EL PASO COUNTY PLANNING AND COMMUNITY DEVELOPMENT DEPARTMENT

GRADING AND EROSION CONTROL PLAN CHECKLIST

Revised: July 2019

SITE GRADING & EROSION CONTROL PLAN

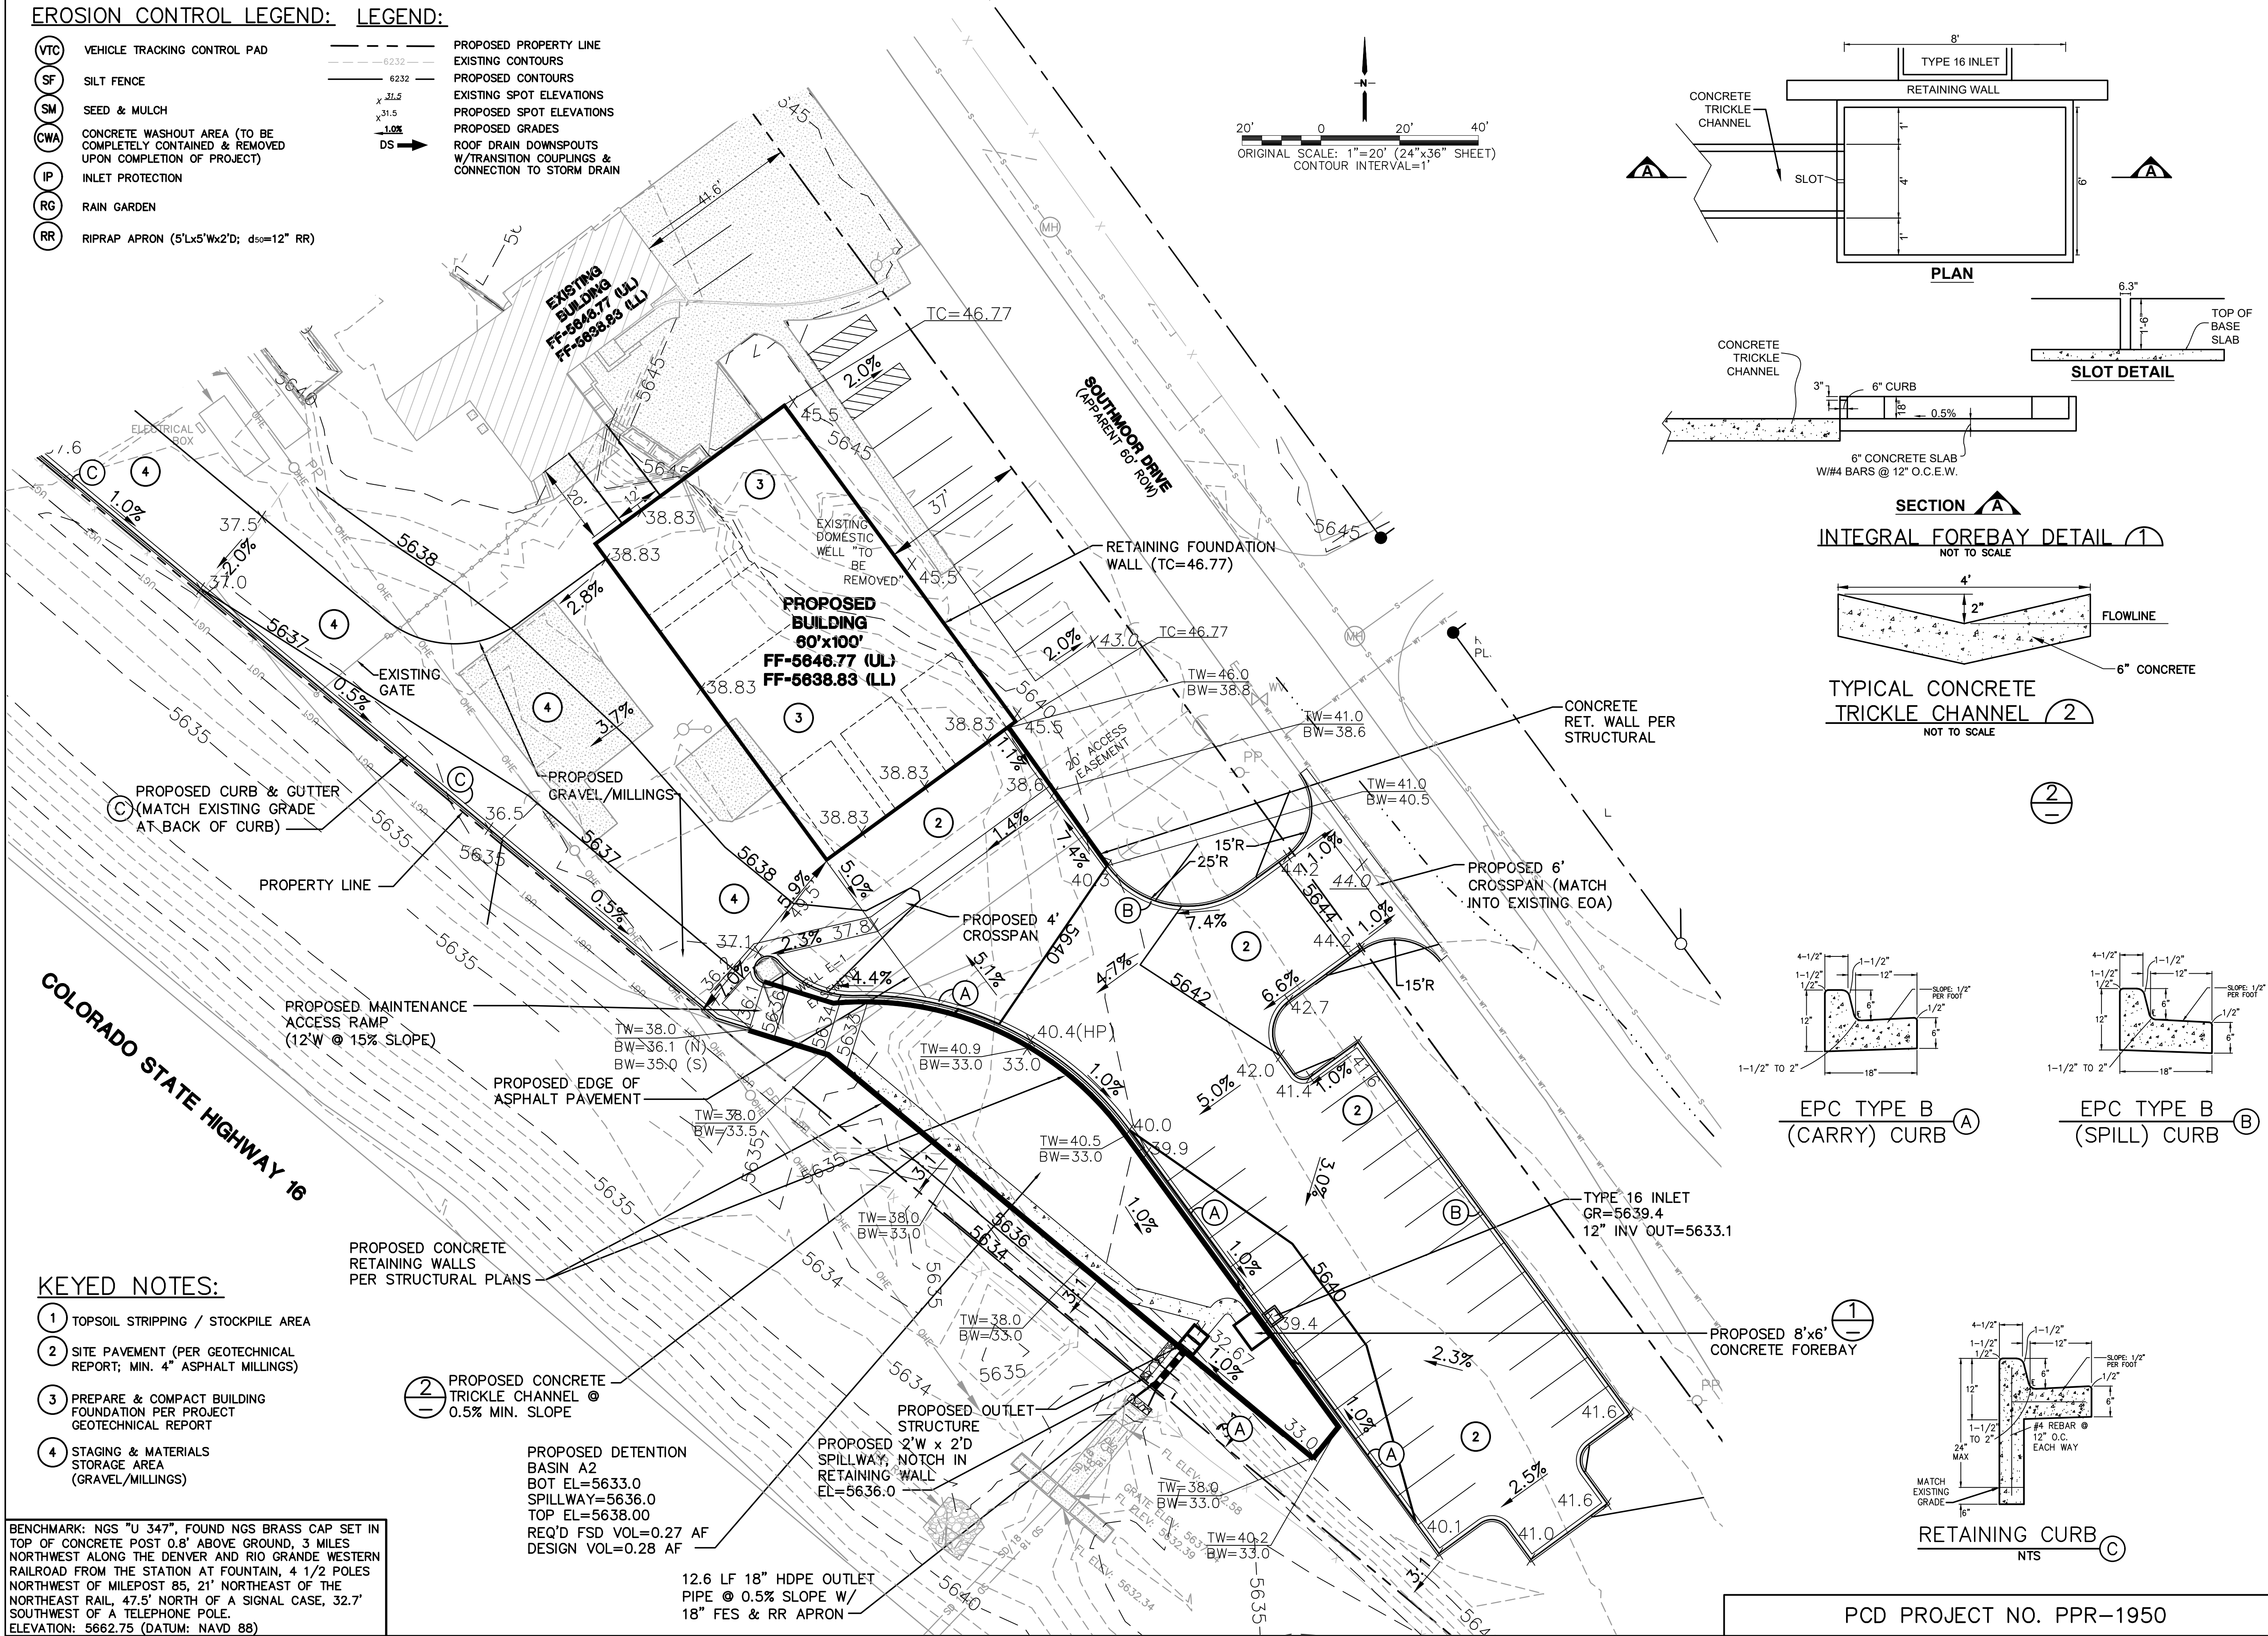
See comment in GEC
 plan

Delineate the limits of
 disturbance
